**PLANNING DEPARTMENT
DEVELOPMENT SERVICES DIVISION
600 2nd Street NW, Ground Floor, 87102
P.O. Box 1293, Albuquerque, NM 87103
Office (505) 924-3946**

OFFICIAL NOTIFICATION OF DECISION

Project# PR-2022-007613
Application#
SD-2022-00204 PRELIMINARY/FINAL PLAT

For all or a portion of: **TRACT 1-A-1-A, LANDS OF PARKING OF AMERICA** zoned **NR-C**, located at **2801 YALE BLVD SE between RANDOLPH RD and SUNPORT BLVD** containing approximately **5.6466** acre(s).
(M-15)

Plat of
Tract 1-A-1-A-1 and Tract 1-A-1-A-2
Lands of Parking Company of America
 Section 33, Township 10 North, Range 3 East, N.M.P.M.
 Albuquerque, Bernalillo County, New Mexico
 August 2022

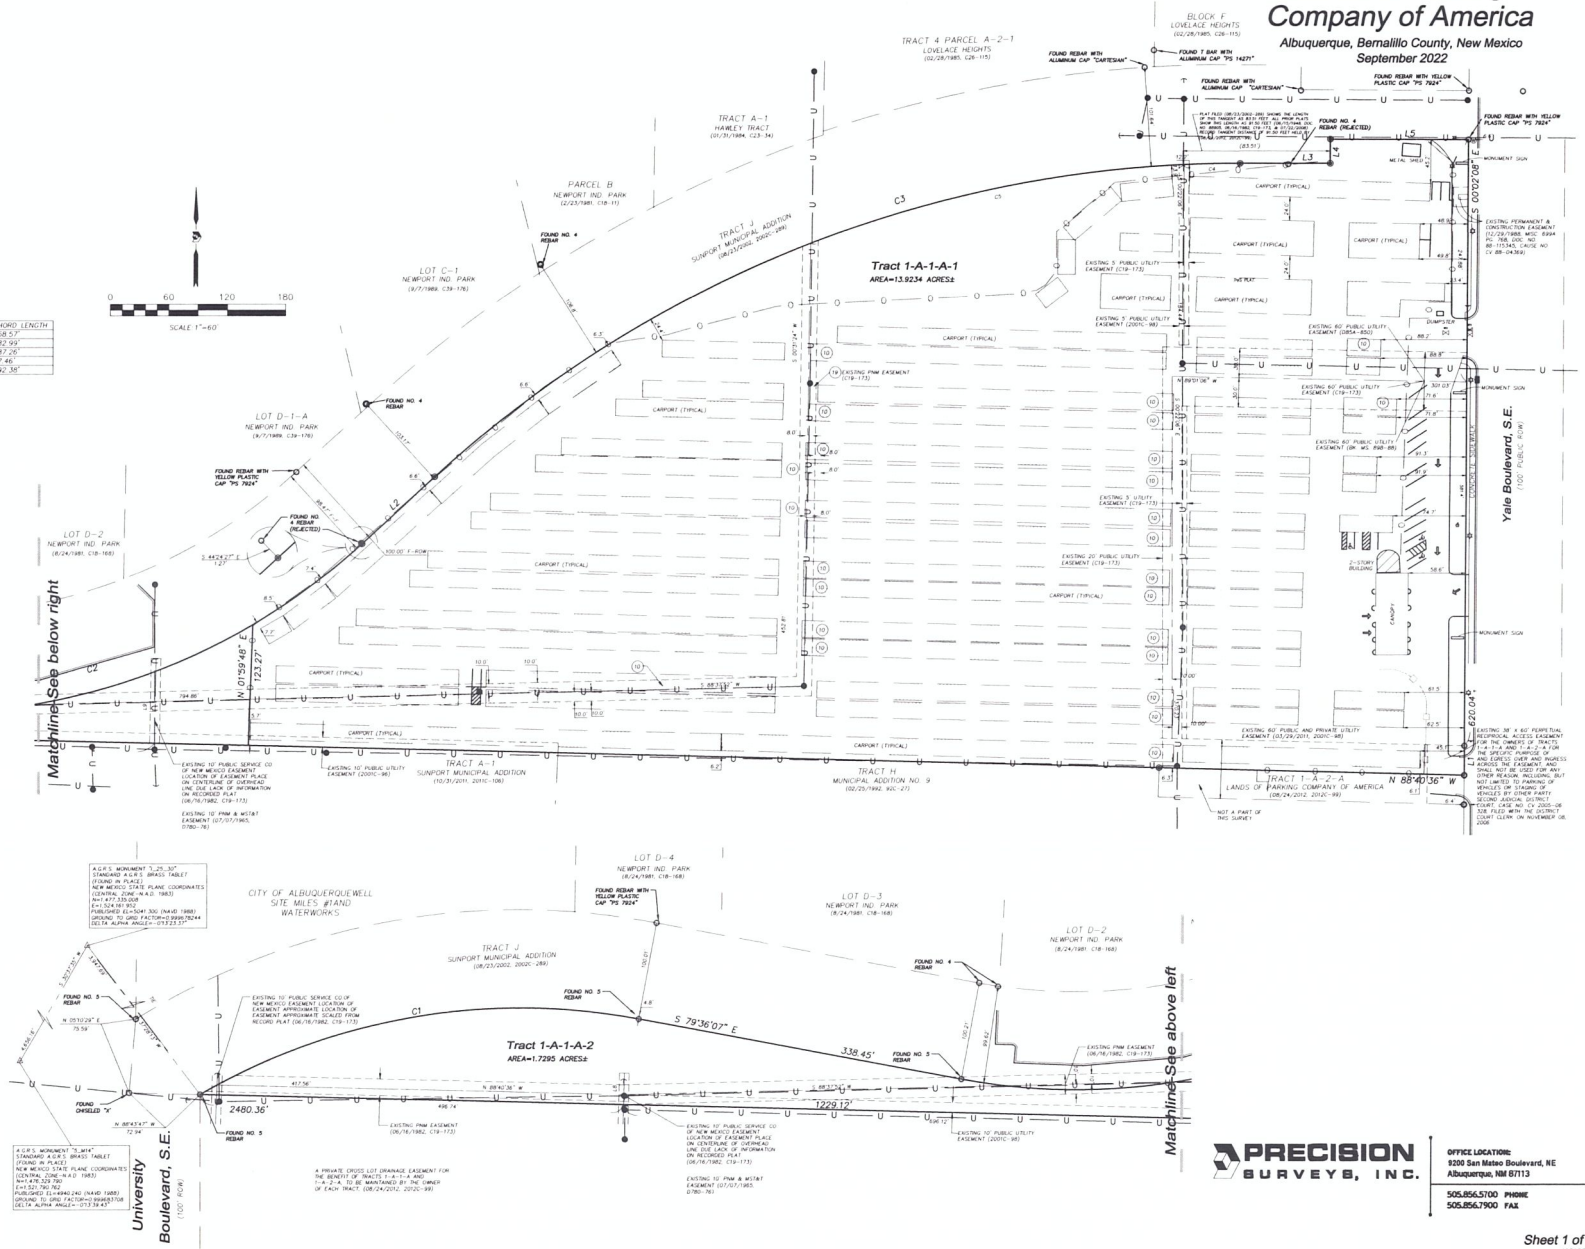
1. Final sign-off is delegated to Hydrology for the addition of a cross lot drainage easement note on the Plat.
2. Final sign-off is delegated to Transportation for the addition of a cross access easement to be shown on the Plat.
3. Final sign-off is delegated to Planning for the application number to be added to the Plat.
4. The applicant will obtain final sign off from Hydrology, Transportation, and Planning by February 15, 2023 or the case may be scheduled for the next DRB hearing and could be denied per the DRB Rules of Procedure.
